16 January 2020

TfNSW Reference: SYD17/01620/04  
DPIE Reference: SSD 8903

REDEVELOPMENT OF IVANHOE ESTATE CONCEPT STAGE 1 (SSD 8903)  
2-4 LYON PARK ROAD, MACQUARIE PARK

PLAN OF PROPOSED SUBDIVISION OF
LOT 124 D.P.

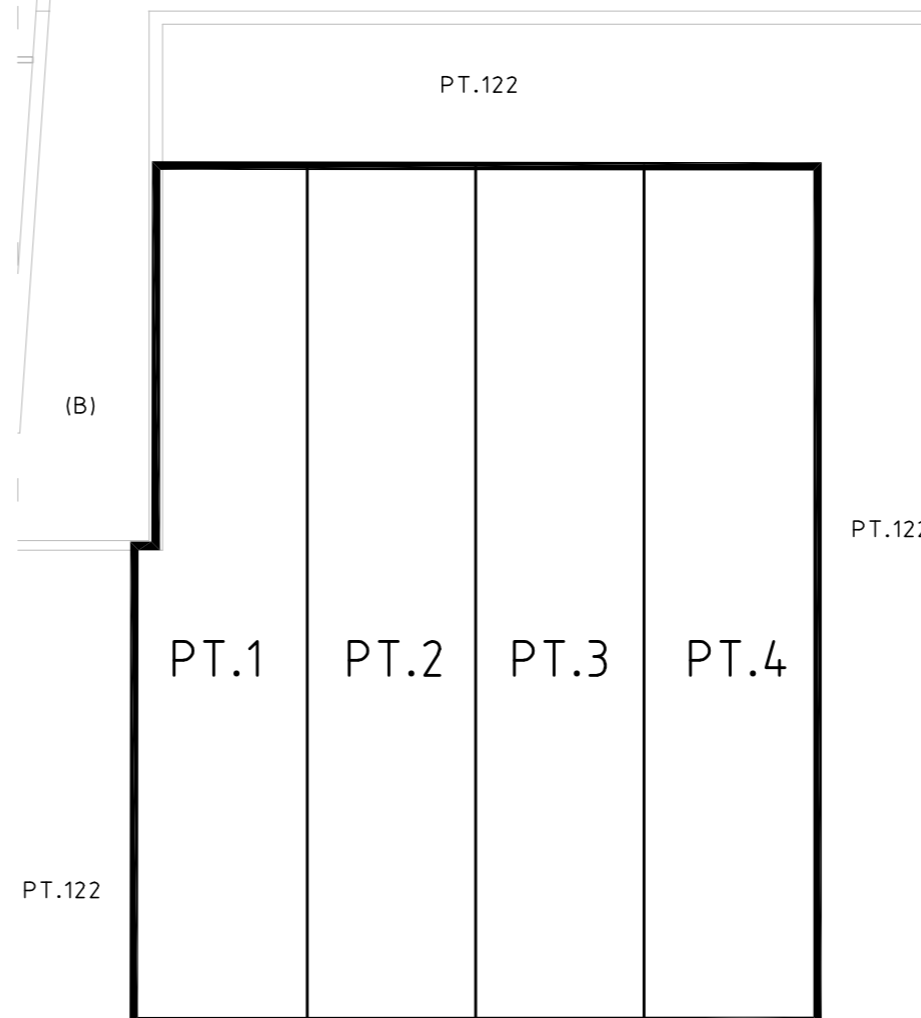
1. A strip of land has previously been dedicated as Public Road by private subdivision (DP 596275) along Herring Road frontage of the subject property, as shown by yellow colour on the attached Aerial – “X”. TfNSW has also previously resumed & dedicated a strip of land as road along the Epping Road frontage of the subject property, as shown by grey colour on the attached Aerial — “X”. The subject property is affected by a road proposal for Macquarie Park Bus Priority Project as shown by pink colour on the attached Aerial “X”.

Therefore, all buildings or structures together with any improvements integral to the future use of the site are to be erected clear of the land required for road (unlimited in height or depth) along Herring Road and Epping Road boundaries.
